# **Consultee Comments for Planning Application**

Application Number: SDNP/23/04631/HOUS

Address: Clematis Cottage High Street Droxford Hampshire SO32 3PA

Proposal: Part two storey extension and single storey extension

SHEET
Elevations-Right/Left side

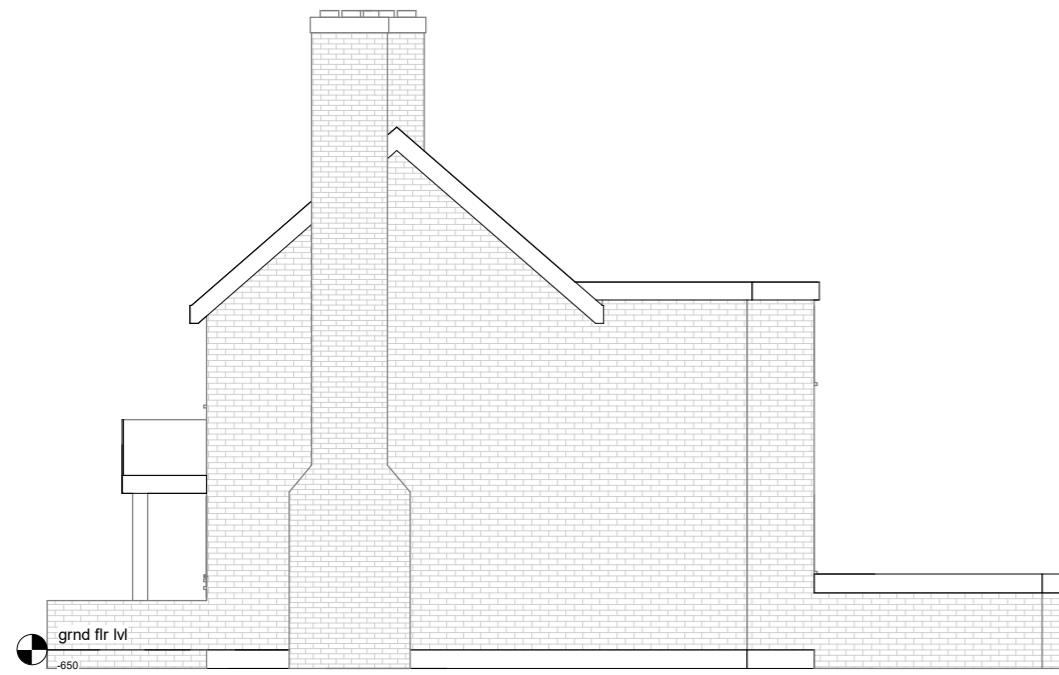
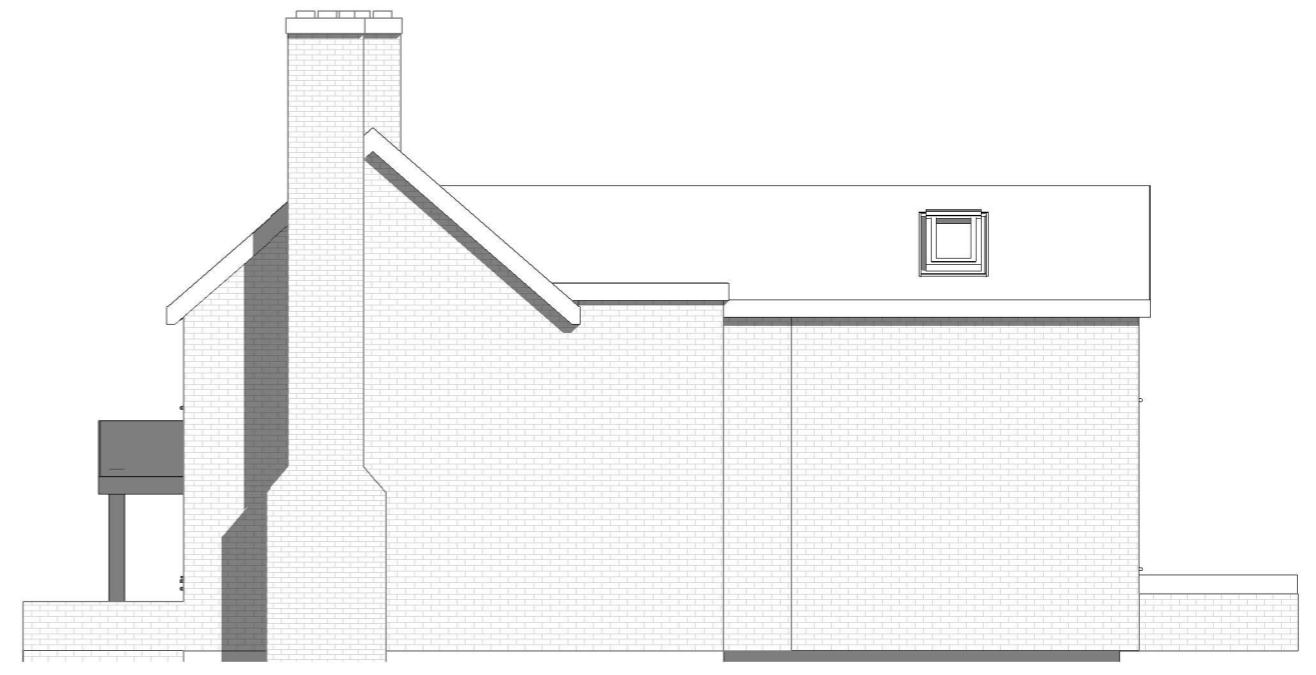
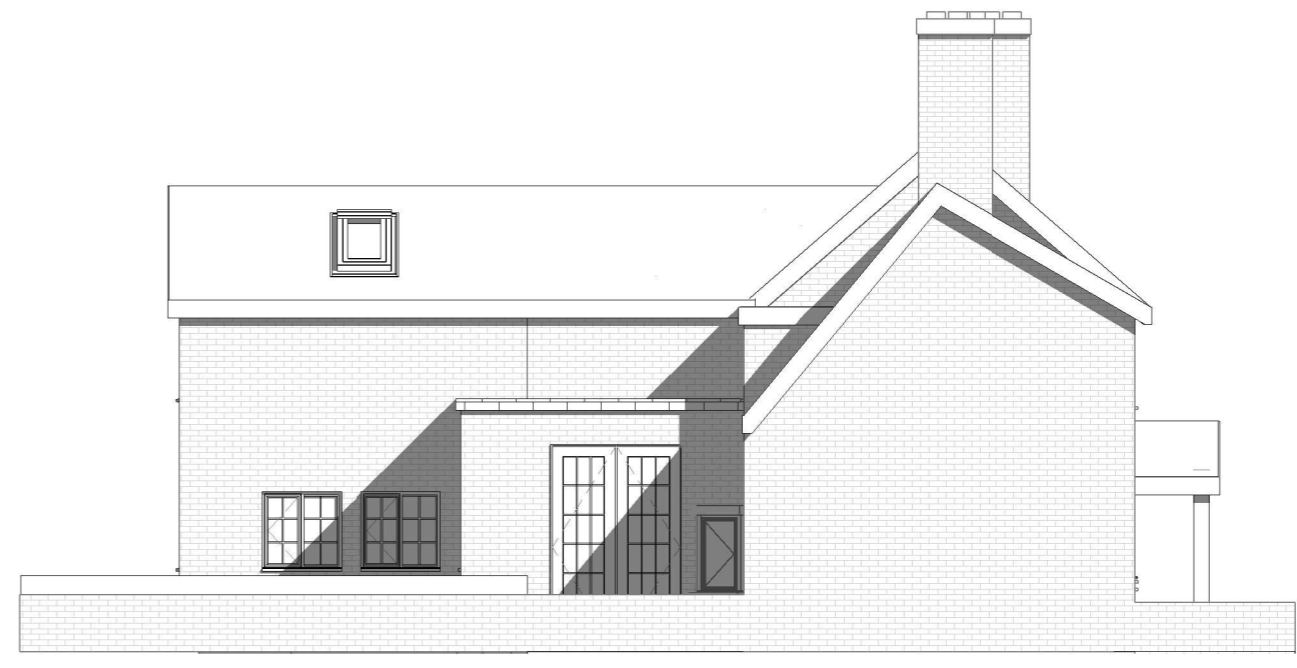
First, it appears some of neighbouring Homeland to the south of Clematis Cottage is part of Clematis Cottage according to the elevation drawings? The line of division between the two cottages ought to be made clearer on the submitted drawings, especially as it appears that changes to Homelands door and porch is proposed to be altered - or is this intended? Please

could this be clarified?
